Petition #: 97-75

ZONING COMMITTEE RECOMMENDATION

REQUEST: Change from O-15(CD) to INST(CD).

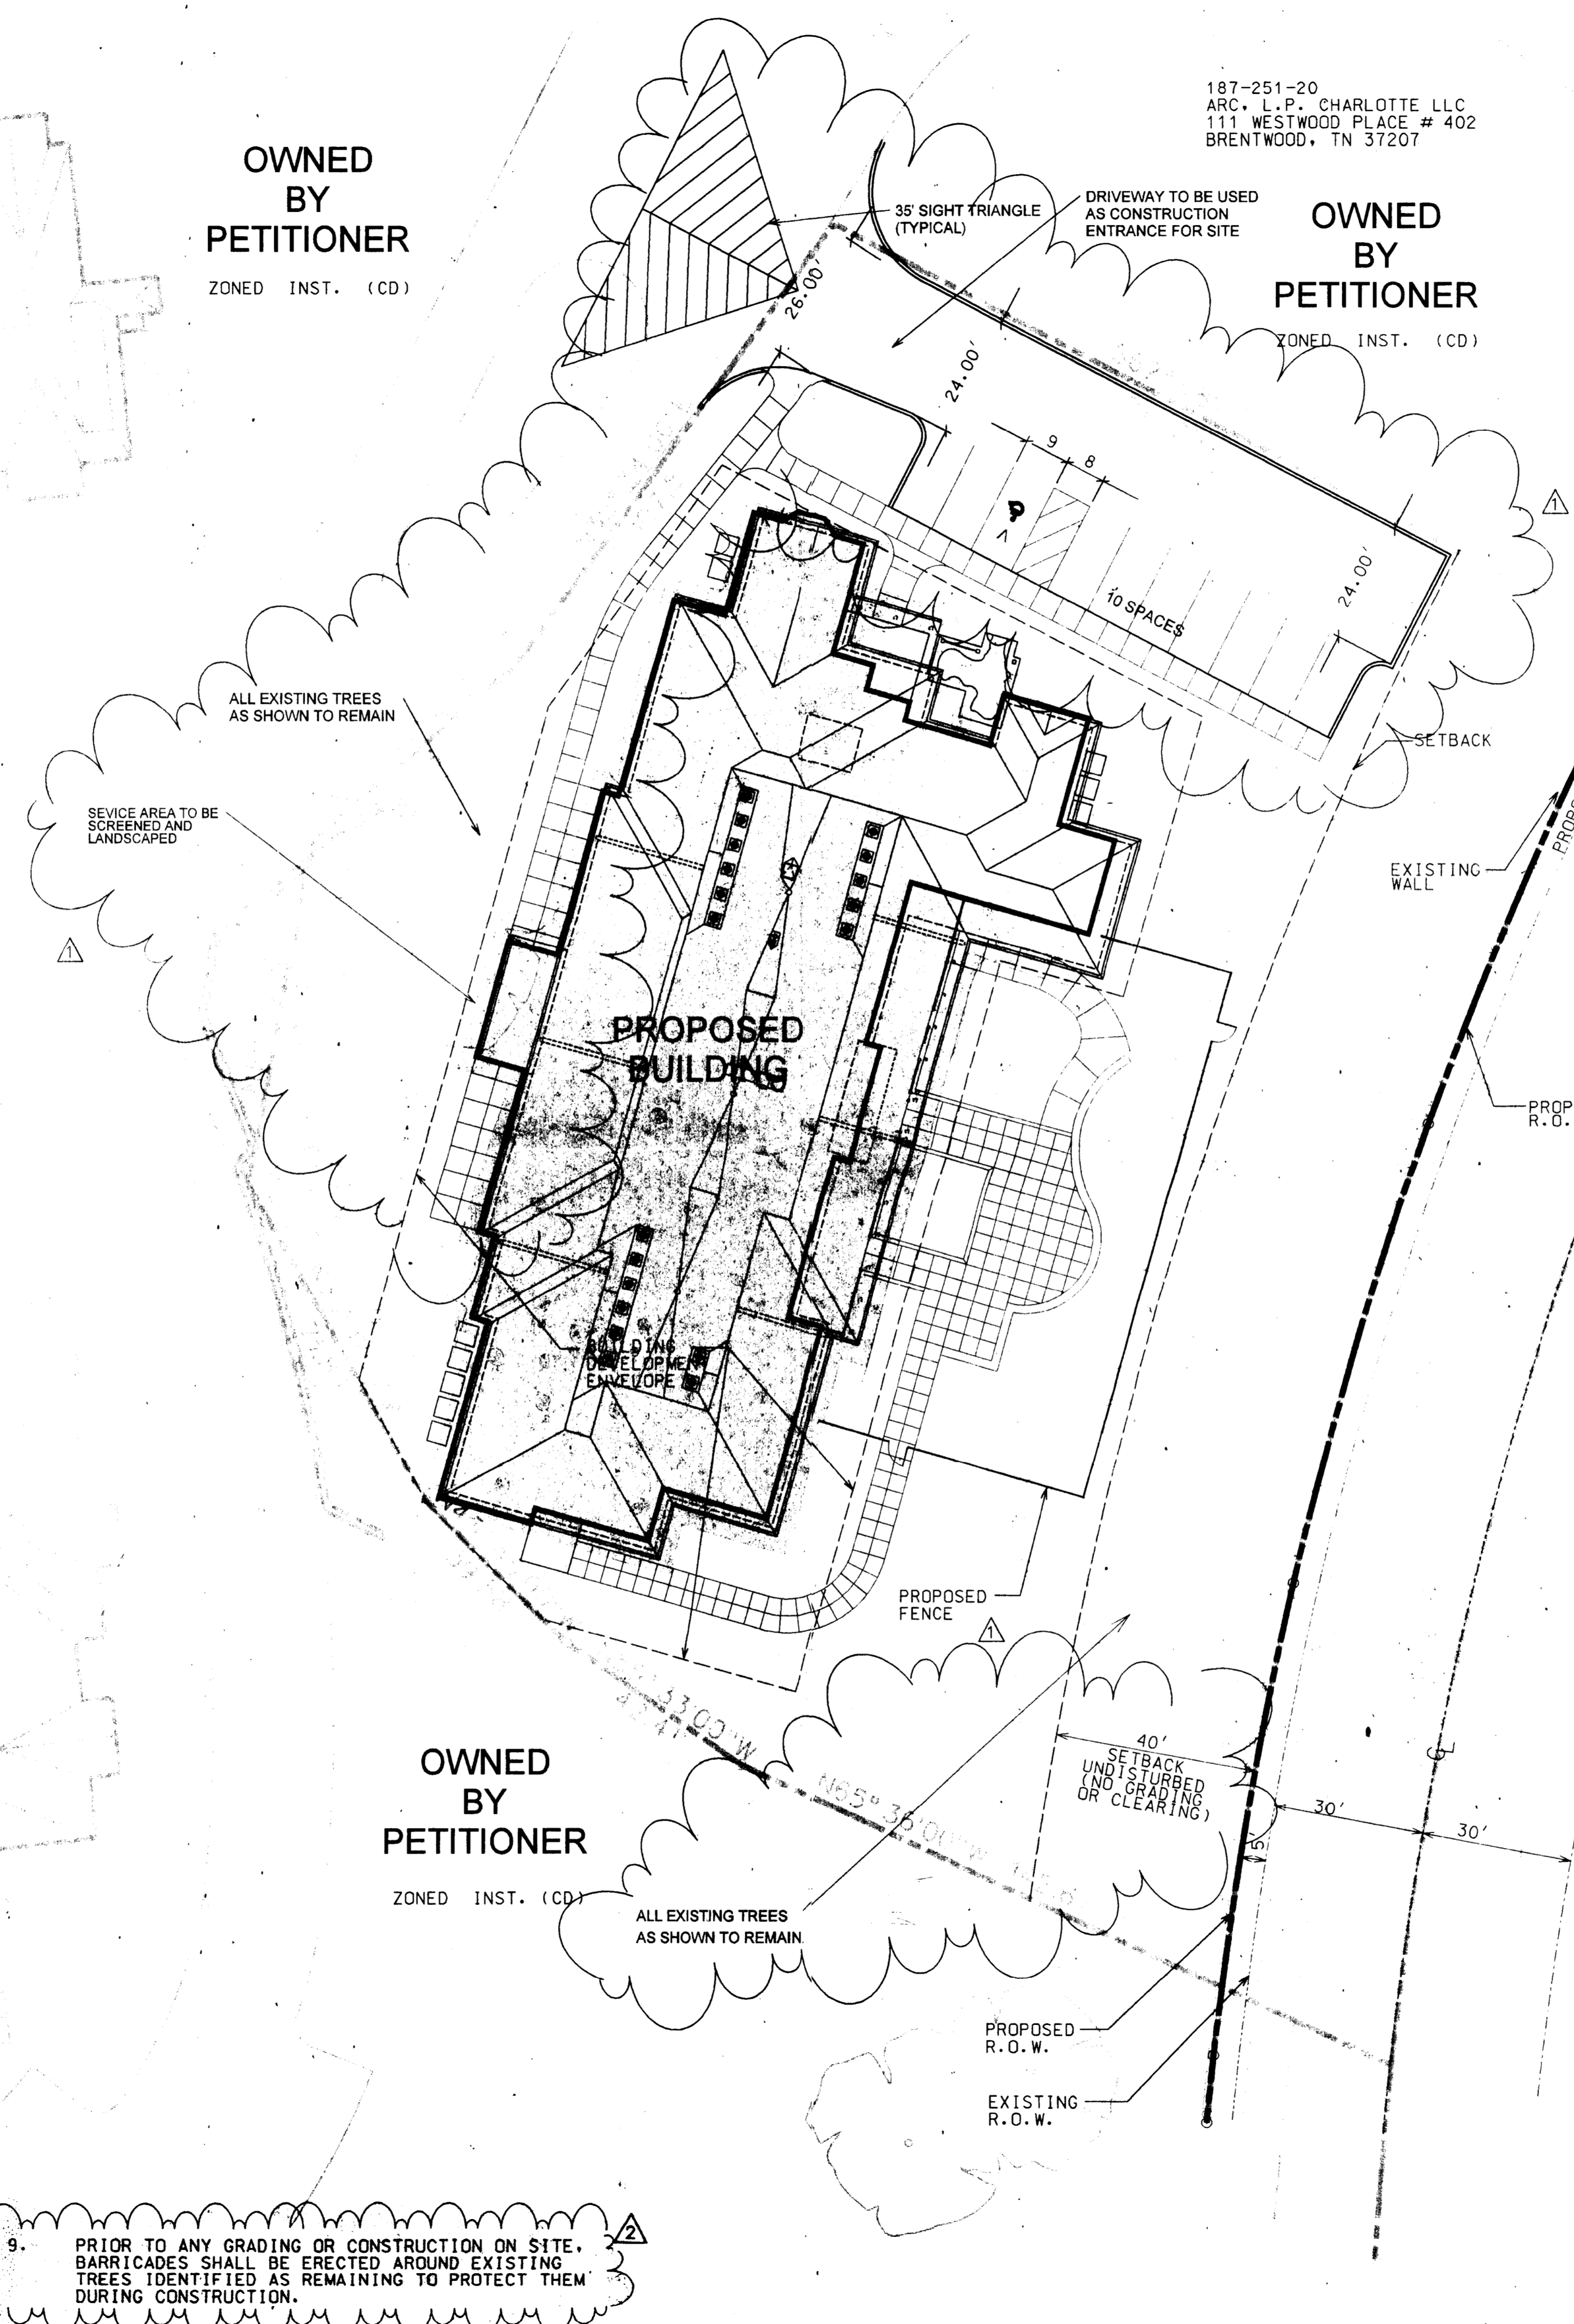
- ▶ Trees shown as remaining will be barricaded for protection during construction.

The primary topic of discussion was the relationship of the proposed addition to Olde Providence Road as compared to the existing Carriage Club facility which is located further away from Olde Providence Road and on lower ground. Ultimately, a majority of the Zoning Committee felt that the proposal was appropriate.

A minority of the Zoning Committee felt that the proposed building was out of scale for the location.
